City of Albuquerque Stormwater Construction Site Inspection Report

ESC File No.	G12E024	Project Name:	Cinnamon Morning Subdivision		
NPDES Id. No.	NMR1003QP/NMR1003QQ	Location:	2714 Rio Grande Blvd NE		
7/1/2021	Owner	Contractor			
Operator	Vivi Investments	Roku Development, LLC			
Contact name & title	Steve Chavez	Steve Chavez			
e-mail	steve.chavez505@yahoo.com	steve.chavez505@yahoo.com			
Contact Phone #	505-415-9533	505-415-9534			
COA Inspector	Thomas Evans	Start/End Time:	9:20 AM-9:30 AM		
Construction Phase:	Grading/Earthwork				
Type of Inspection:	Regular	Storm Event	Past Storm Event >0.25"	311/Complaint	
Weather at time of inspection?	Clear		Temperature: ~	74	
Estimated date of last storm 0.25" or greater	6/28/2021

ESC-1

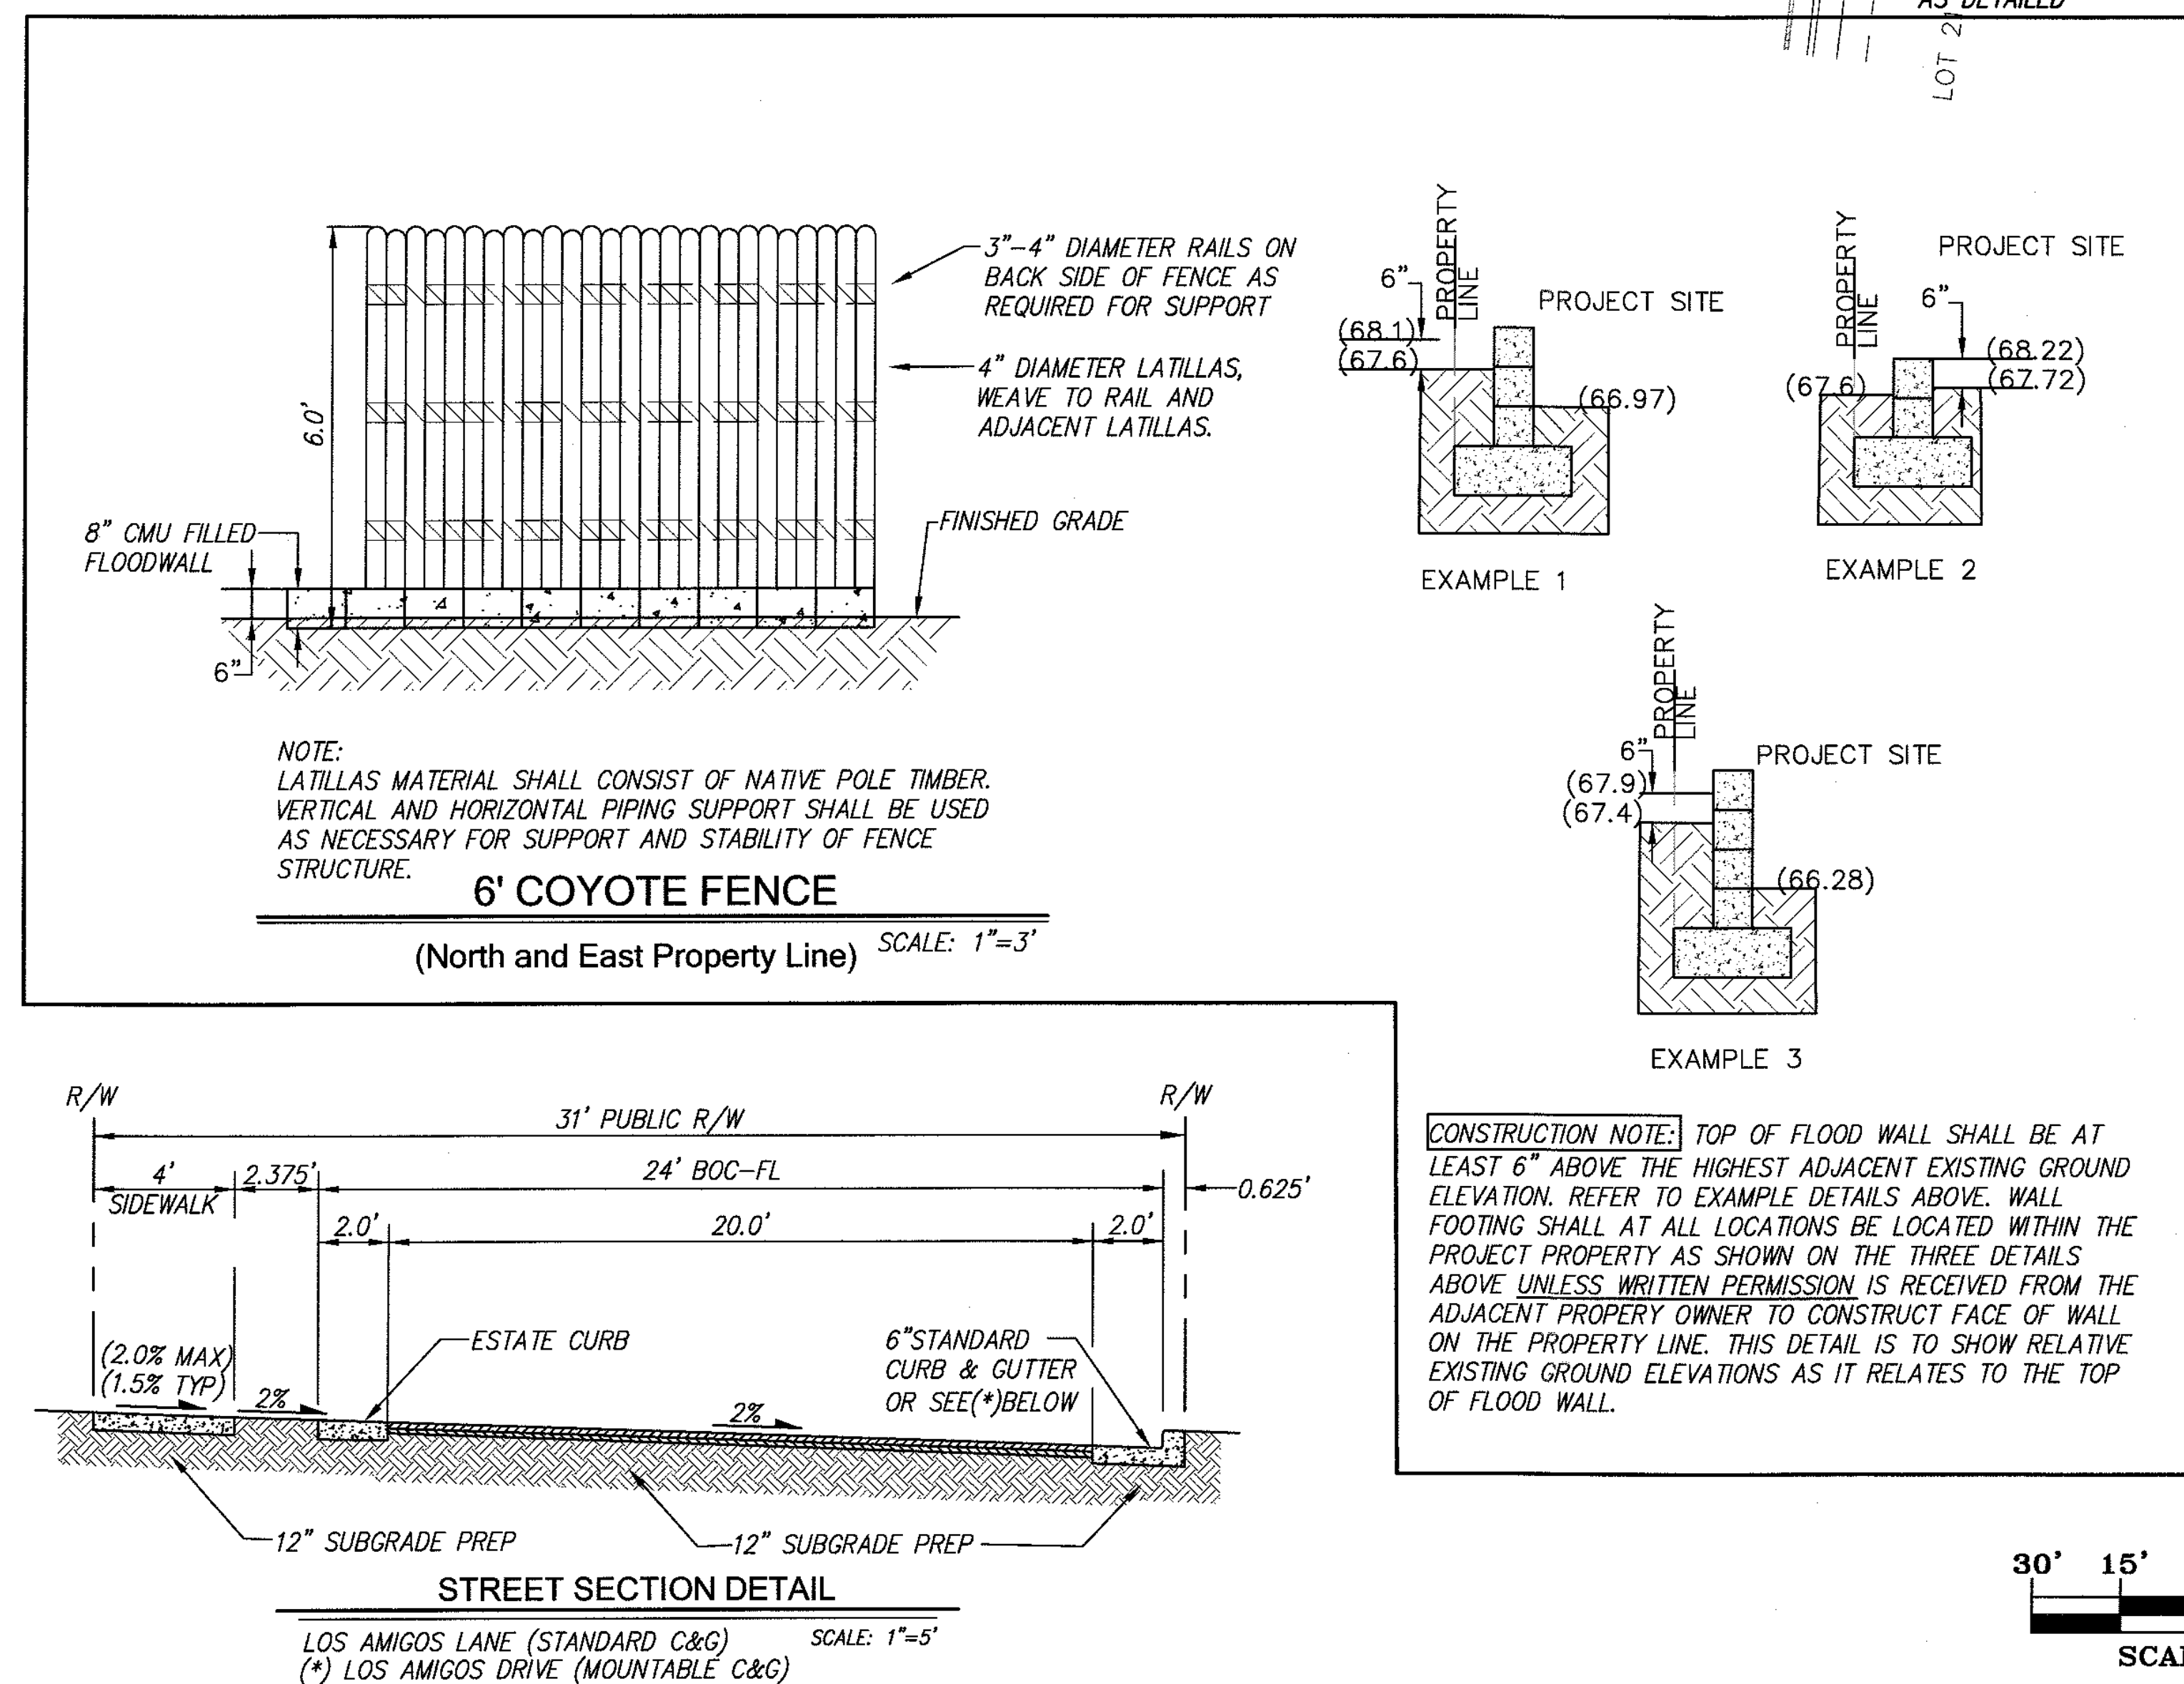
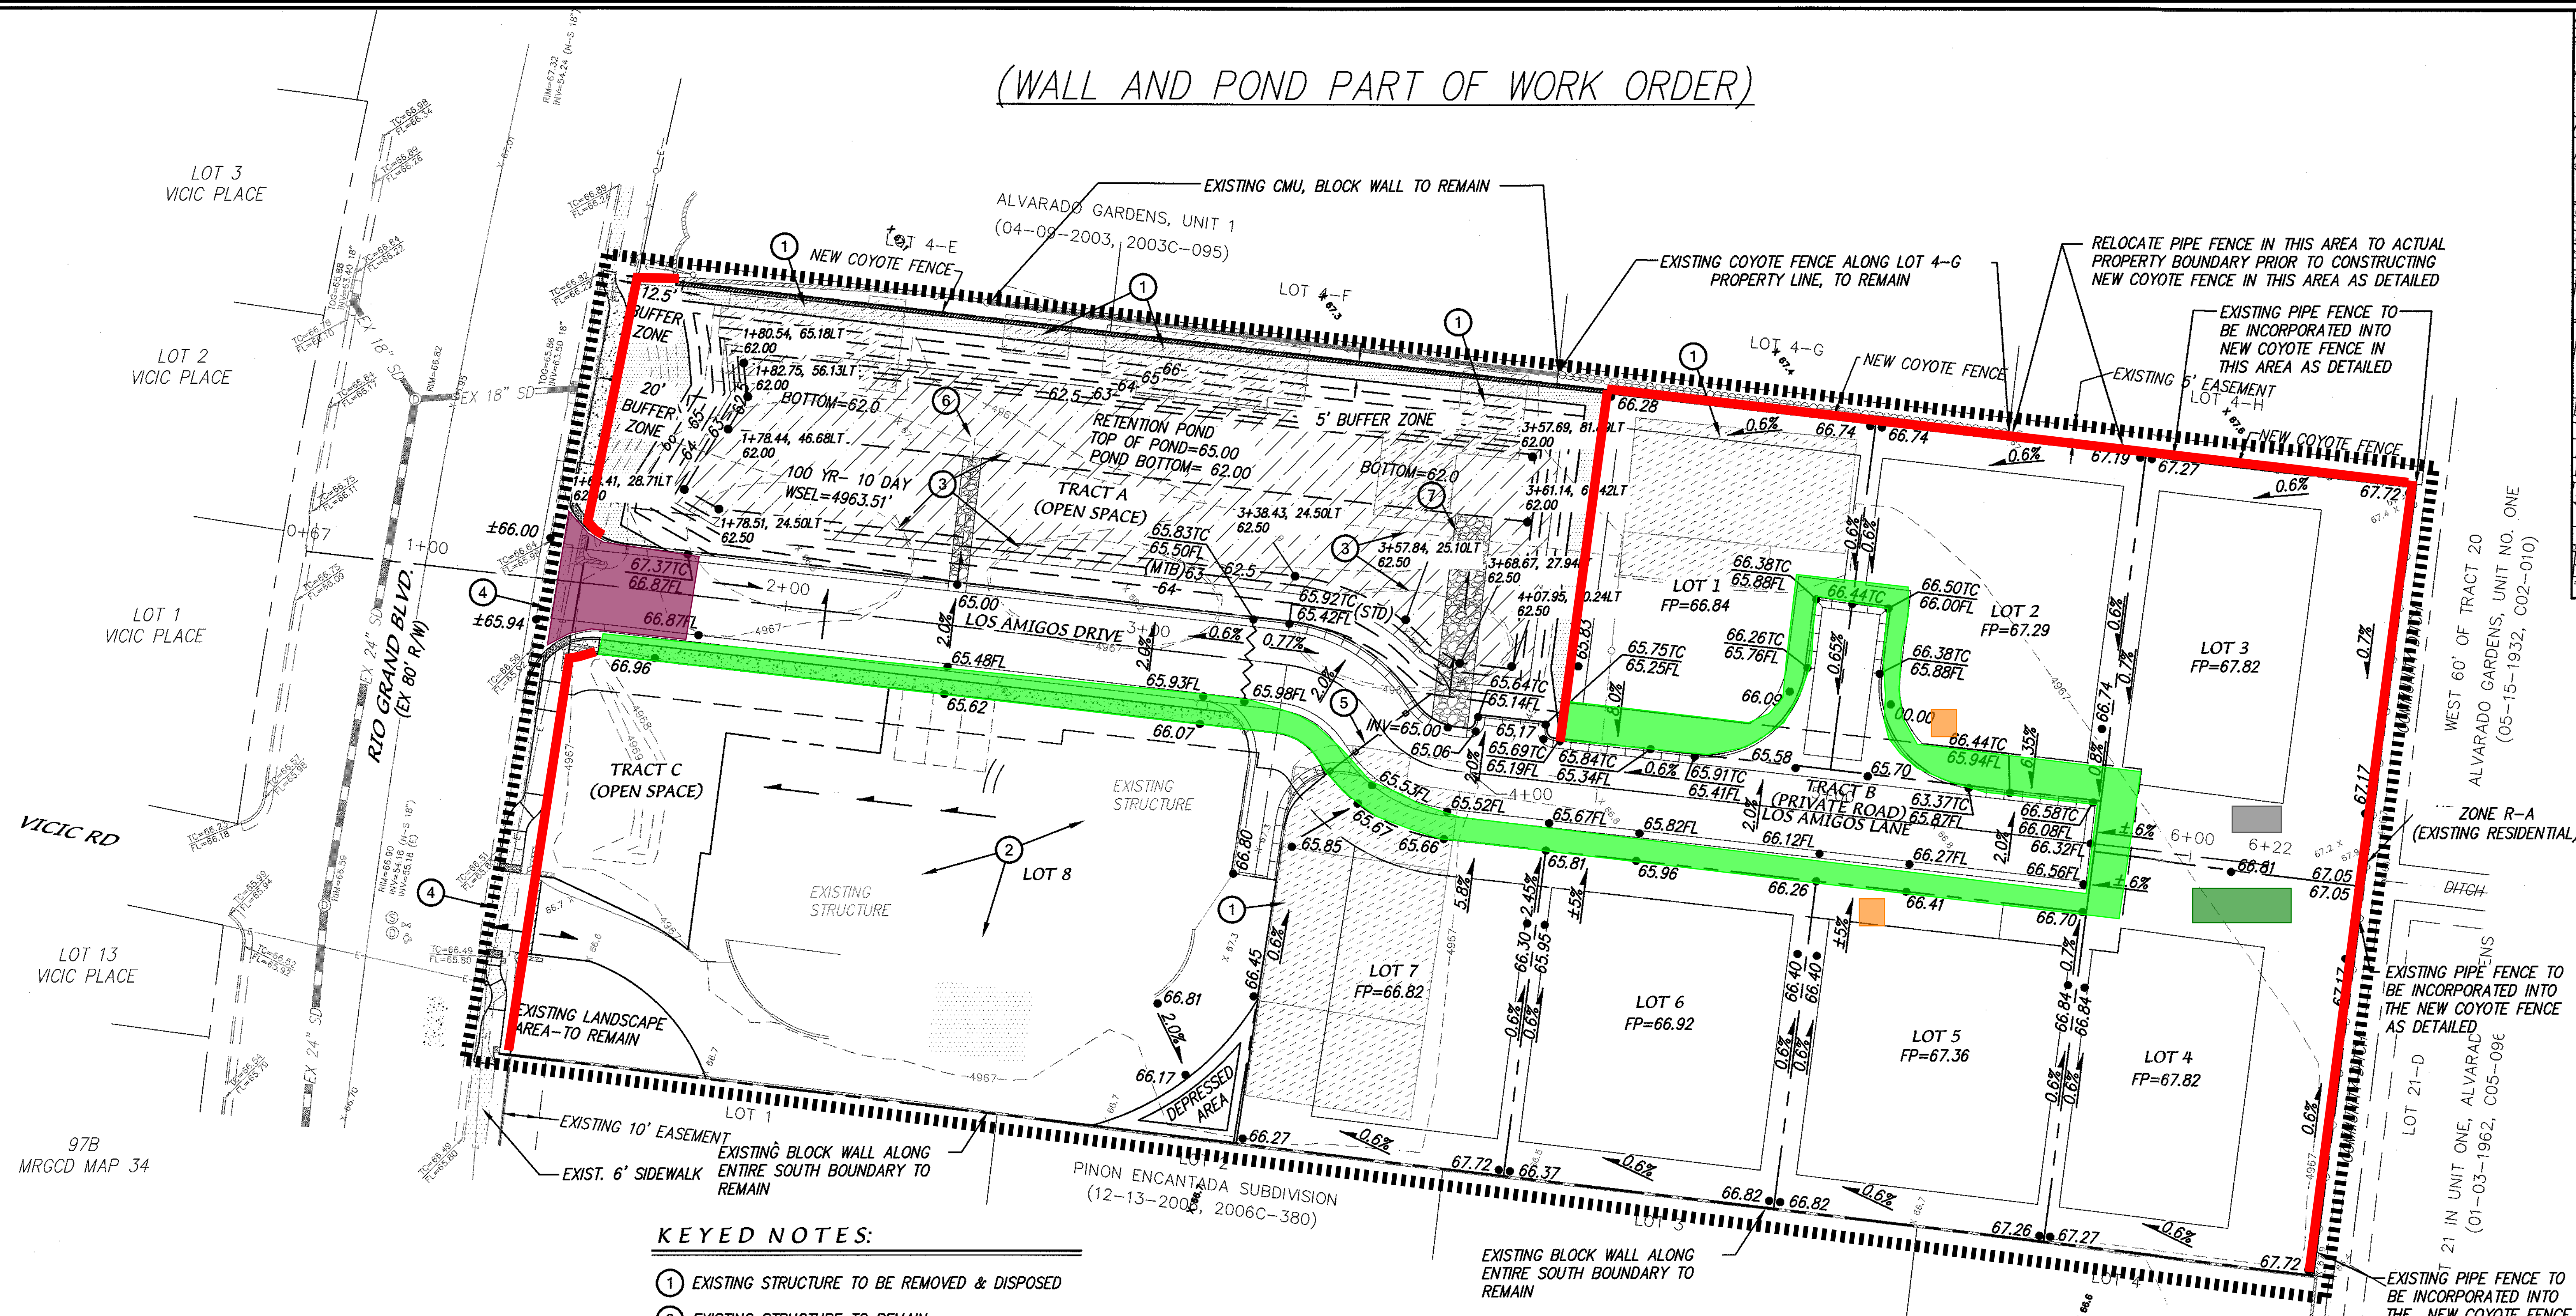
Item Number	Deficiency/ Corrective Action				
1	No perimeter BMP along West boundary of site. Install perimeter BMP as shown on the ESC Plan.				
2					
3					
4					
5
